Our Ref: AW/86/20/HH

**Town & Country Planning Act 1990 (as amended)
Town & Country Planning (Development Management Procedure) (England) Order 2015
Application for Planning Permission for Works or Extension to a Dwelling**

Development Proposed single storey rear extension.

Location 3 Balmoral Close Aldwick

Proposed site plan

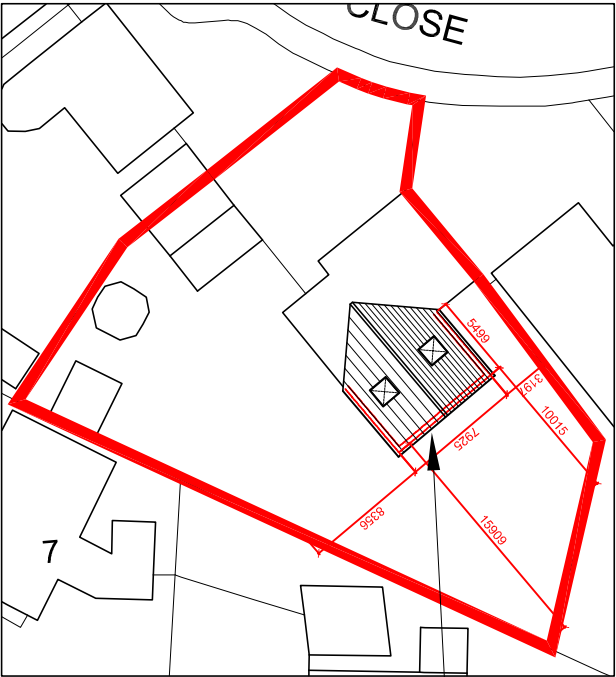
Block Plan: You are required to include dimensions on the block plan from the proposed extension to all site boundaries.
